Project: ..... Reiter Residence, 35 Pleasant St., Portland, ME

Date: ..... 14 September 2015

Re: ..... Response to Planning Dep't comments received 9/11/15

Memo To: Barbara Barhydt, Shukria Wiar  
From: David Margolis-Pineo  
RE: 35 Pleasant St. – Level II Site Plan Review 2010-138

**Wall & Roof Details**

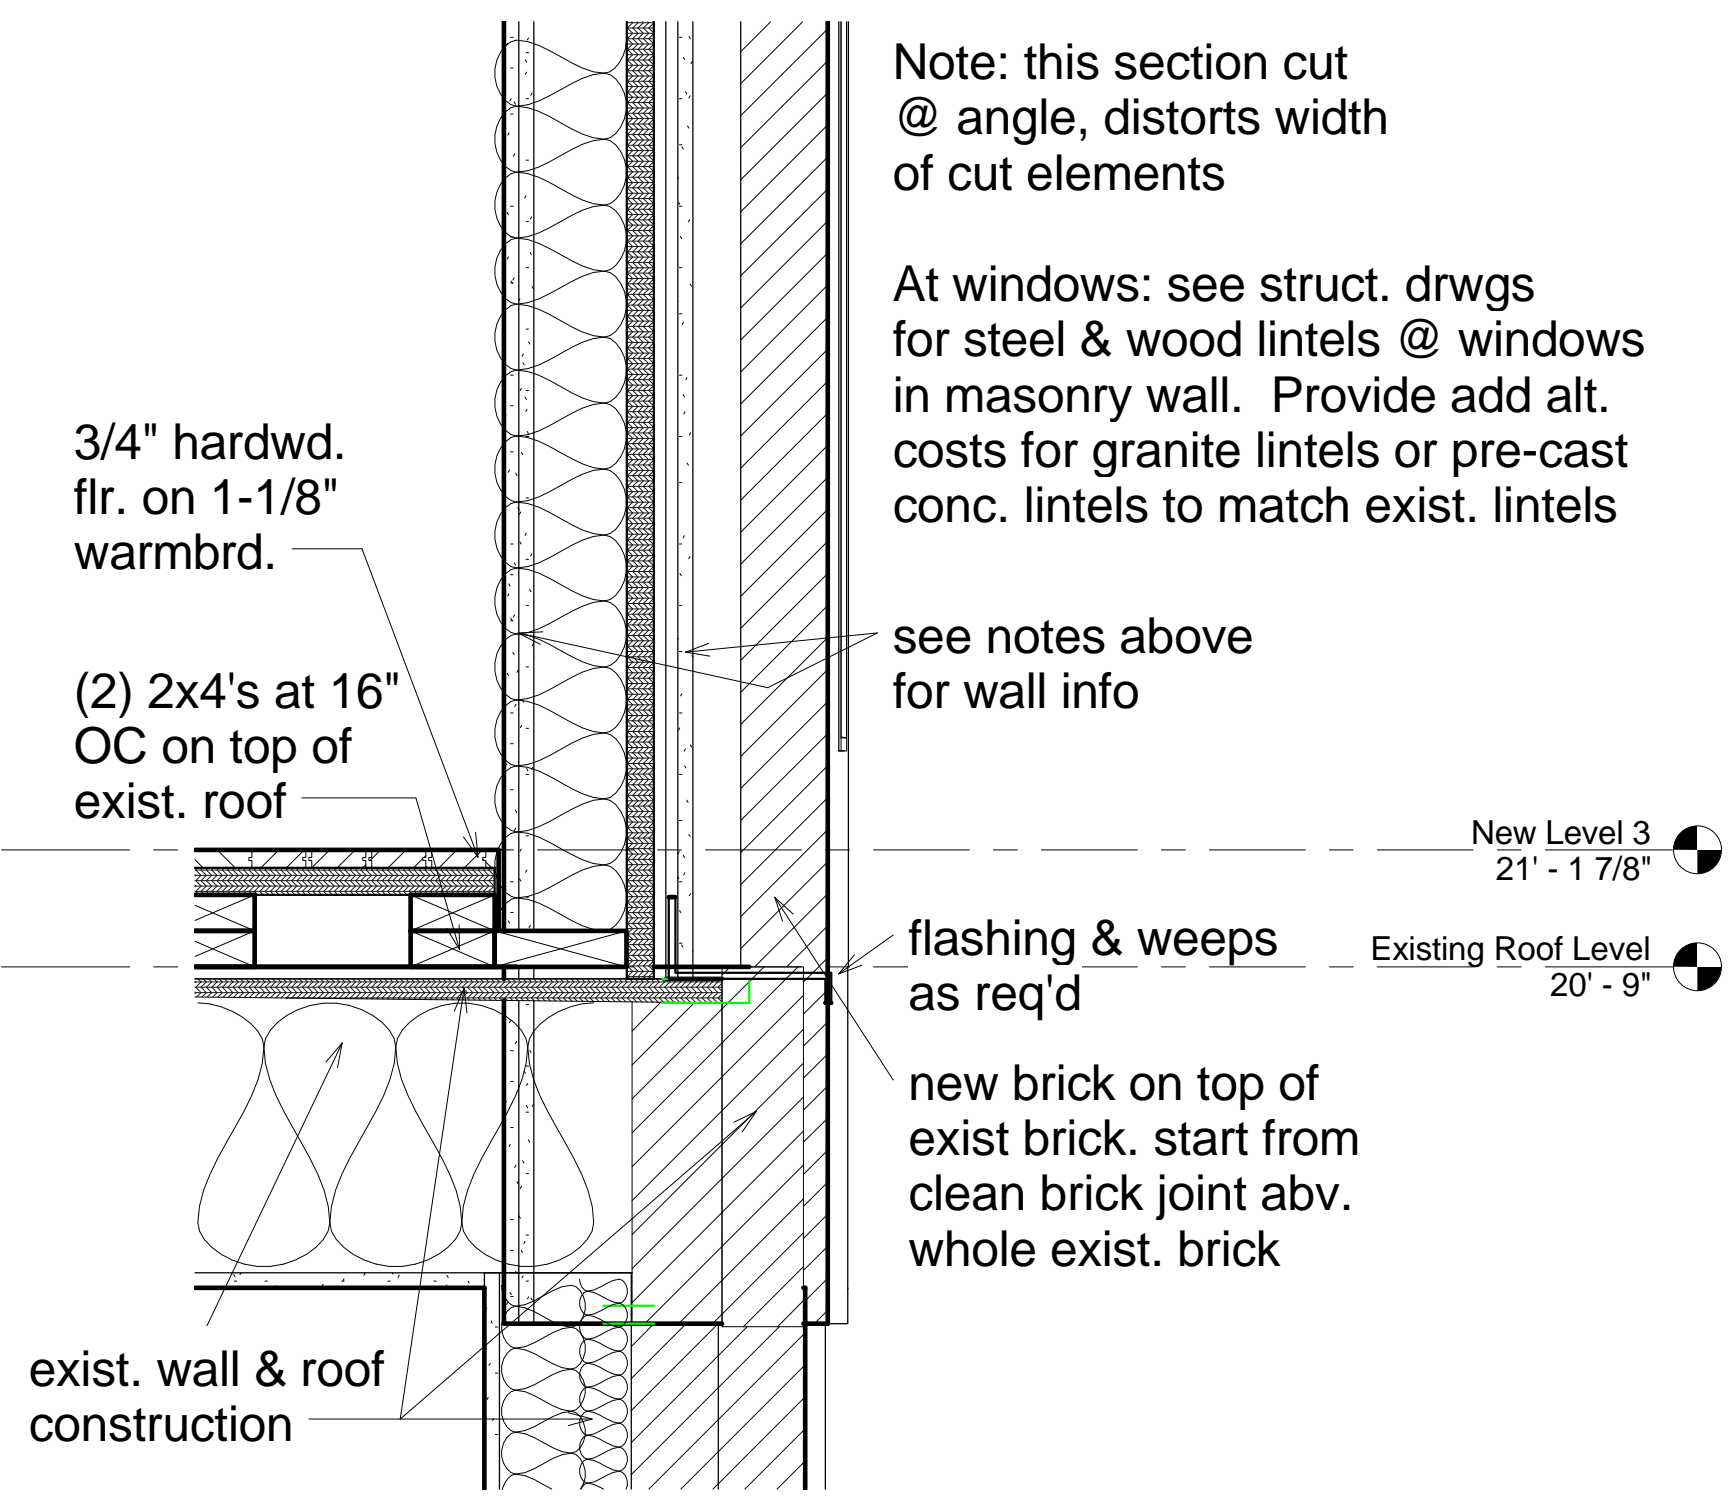
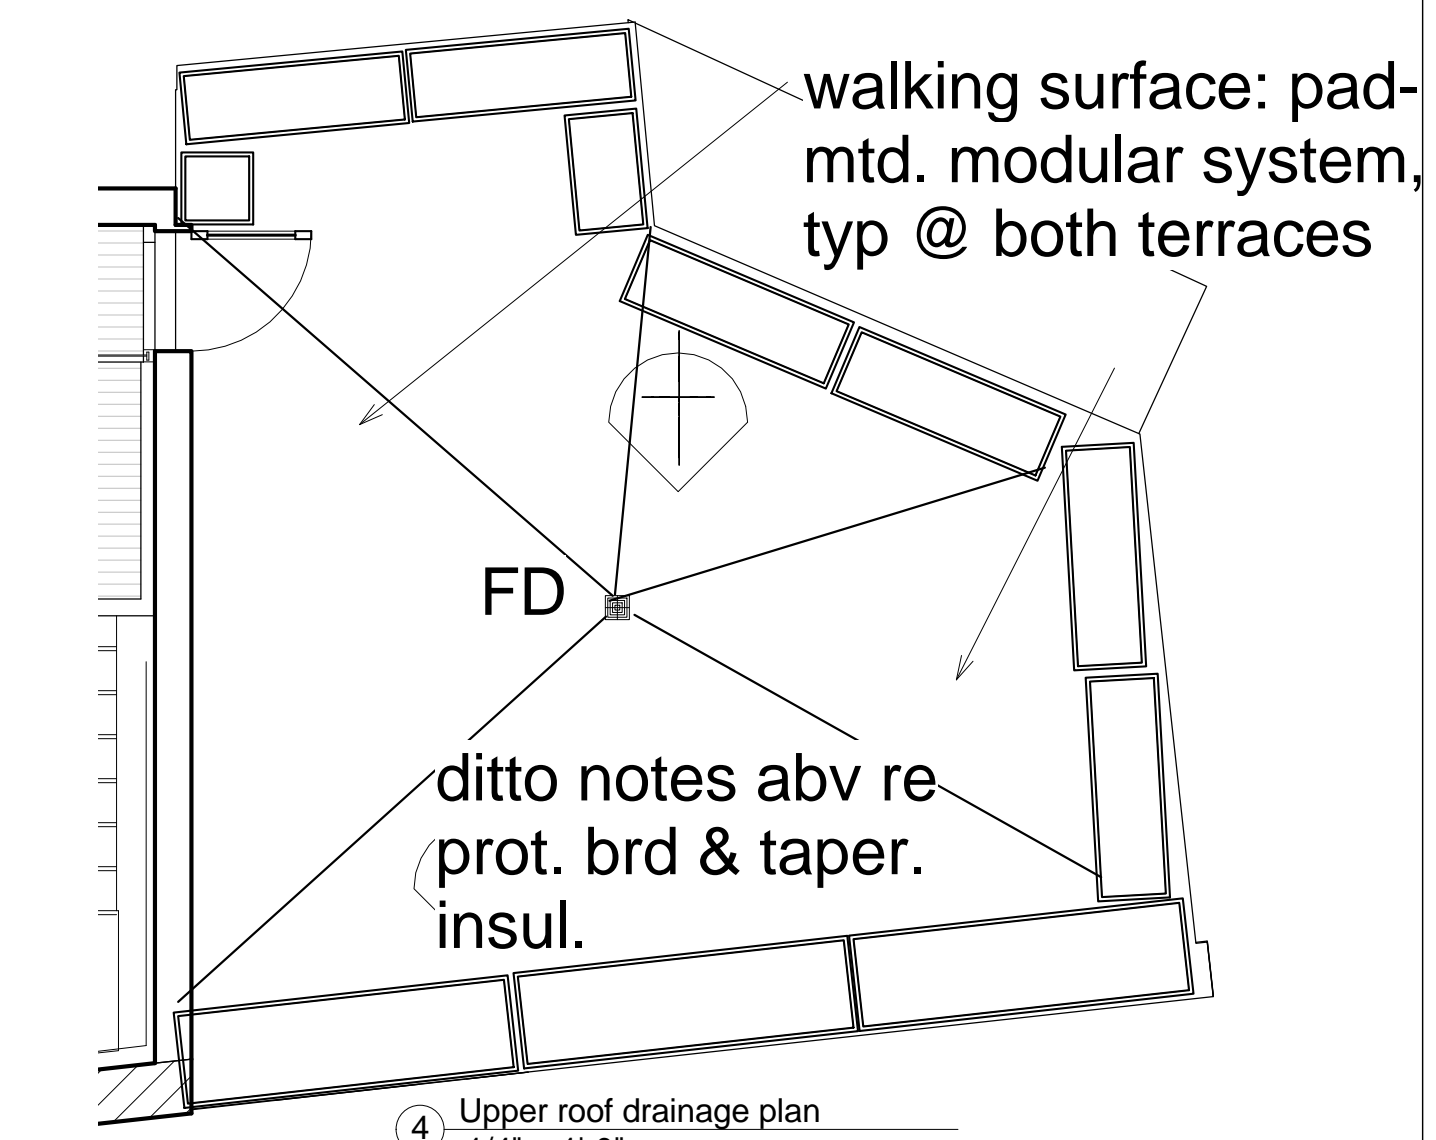
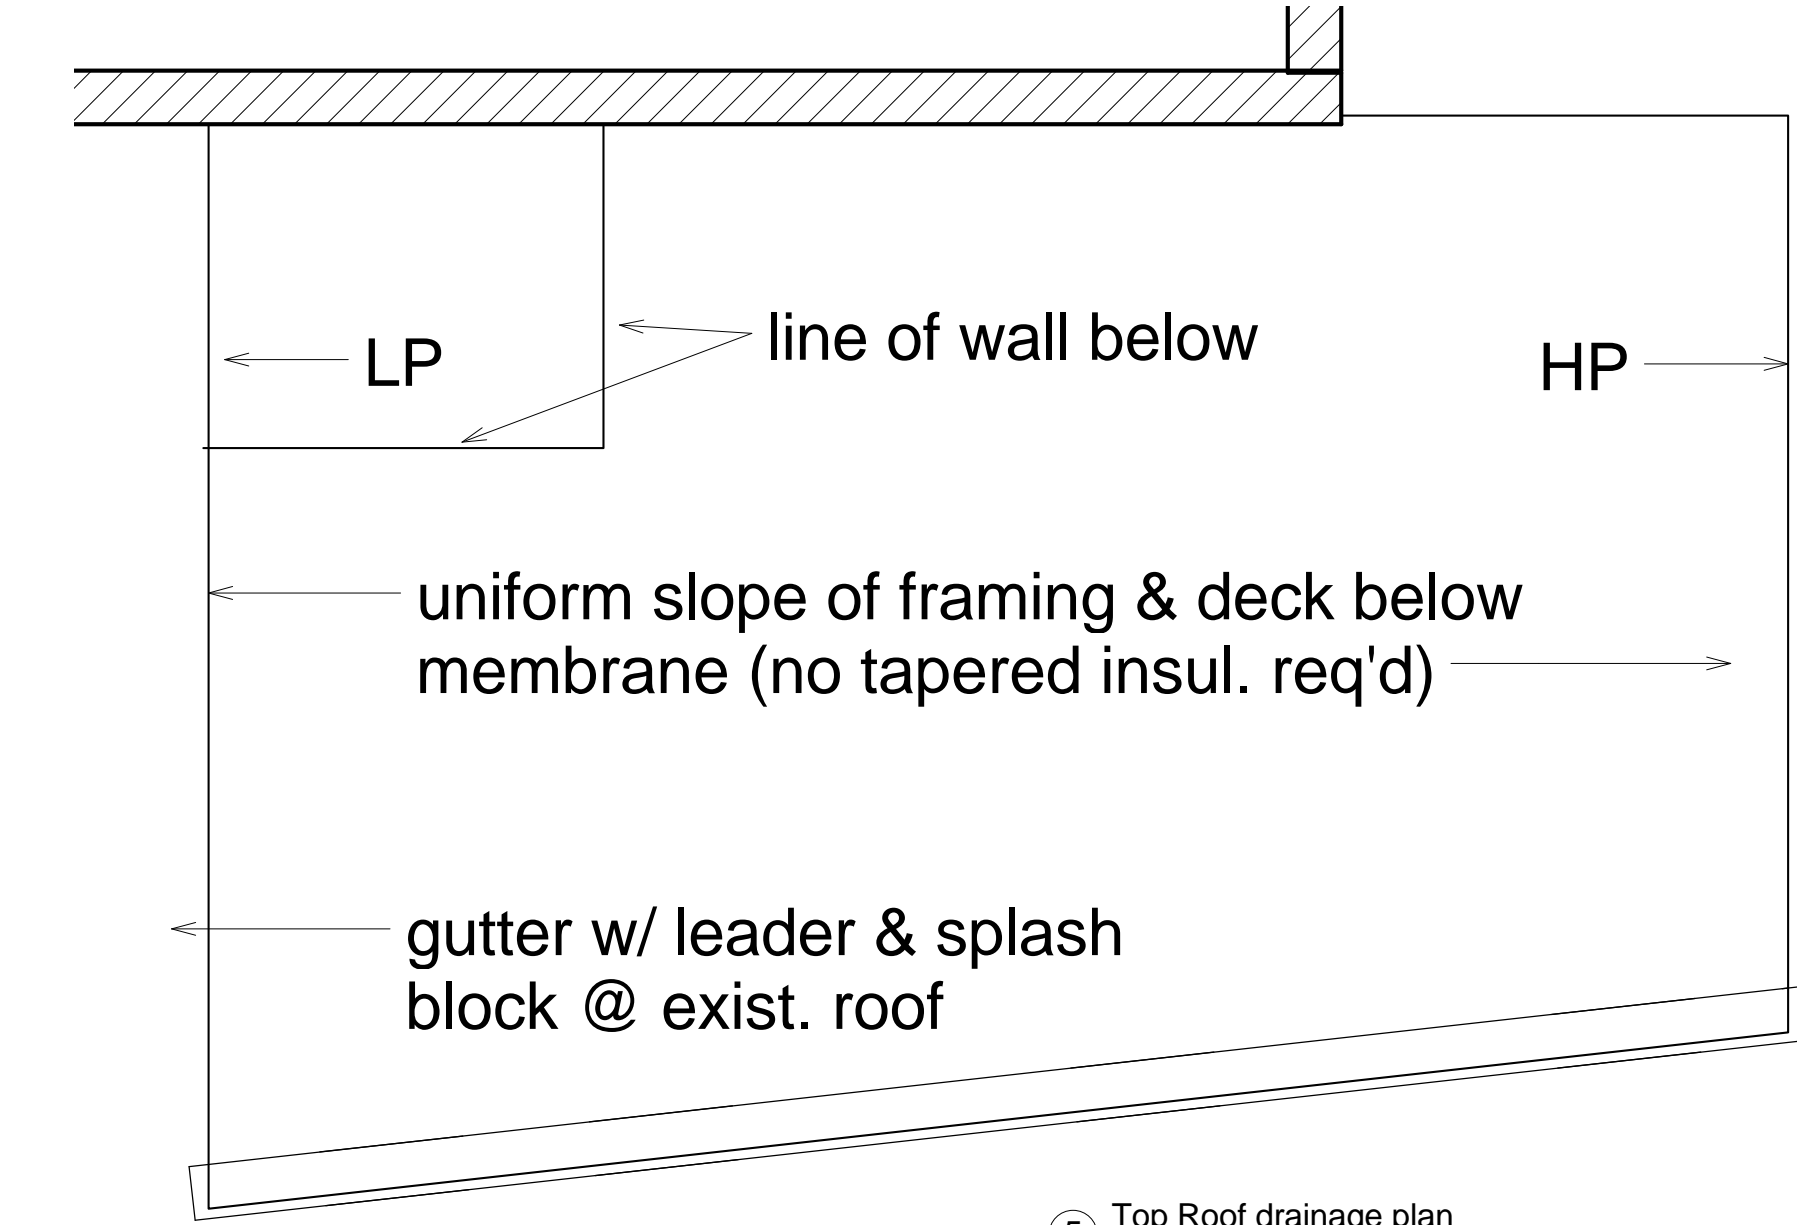
1) The Applicant has noted that an updated survey will be submitted showing topography in the parking area/area of the addition, and the location/elevation of a storm line connection point. If the proposed storm line is associated with roof water, the City DPS may prefer that the pipe discharge to the street in lieu of a direct connection to the combined sewer; the Applicant should verify through David Margolis-Pineo at the Department of Public Services. The Applicant should note that details will be necessary for all work within the Right-of-Way in accordance with the City of Portland Technical Manual (such as sidewalk repairs, pipe trench, etc).
